Subject: 6216 Ponderosa Road
Sanford, NC 27332
Framing Inspection Letter
Harnett County Permit #: SFD2008-0048

Based on the request of the Contractor, I reviewed 4 items from the framing inspection notice for code compliance. My assessment and recommendations are as follows:

**CEILING FRAMING
PLAN**

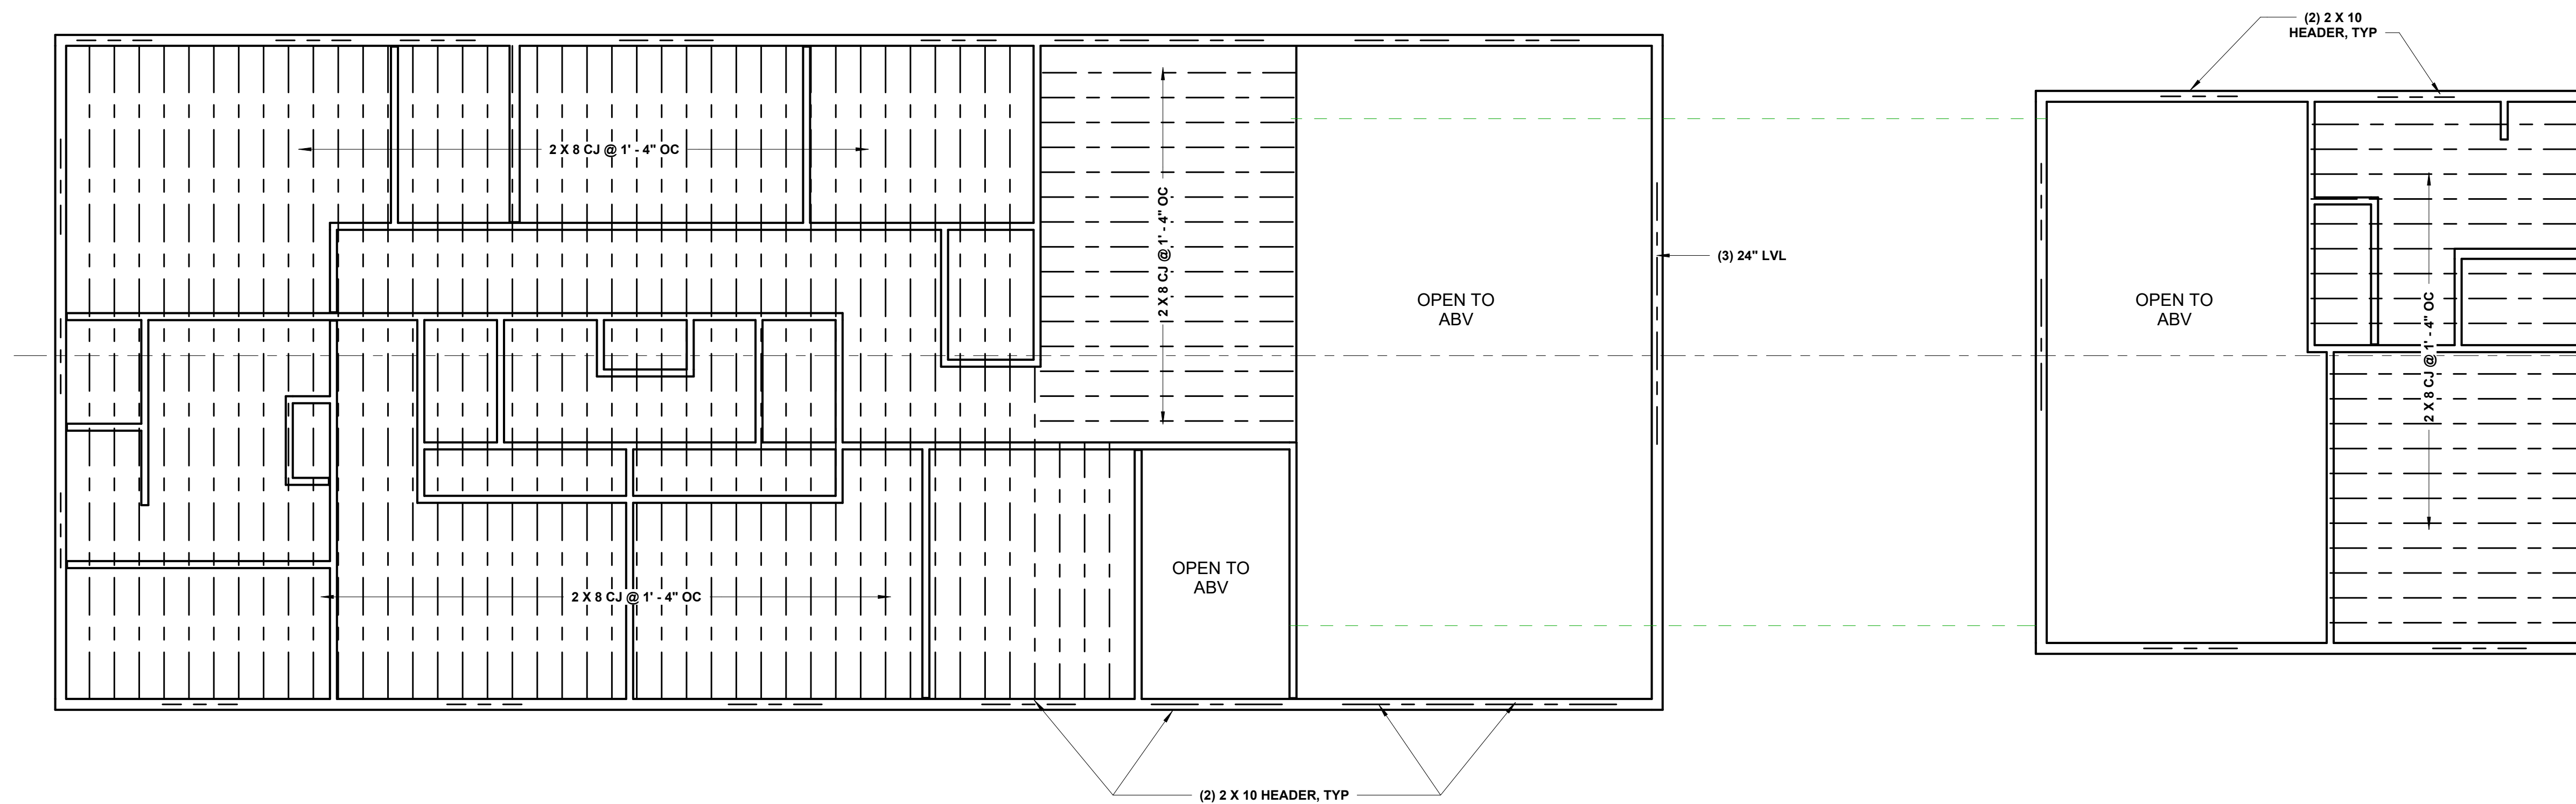
- Item 1: The front porch beam has some unsupported splices. The Contractor added 2 – ¼”x 3” structural screws on each side of the unsupported splice of the front porch beam. He also added ½” OSB to one side of the porch beam. The front porch beam is acceptable.
- Item 2: The ceiling joists in the small hallway are over spanned. The Contractor doubled 2 of the ceiling joists the hallway. The ceiling joists are acceptable.
- Item 3: The double band of the Garage have unsupported splices. A new post was added at the midpoint of each beam. He also added 2 – ¼”x 3” structural screws on each side of the splice. The Garage double bands are acceptable.
- Item 4: The Contractor added a joist to the existing joist at the attic access hole. The new double joists on each side of the attic access are acceptable.
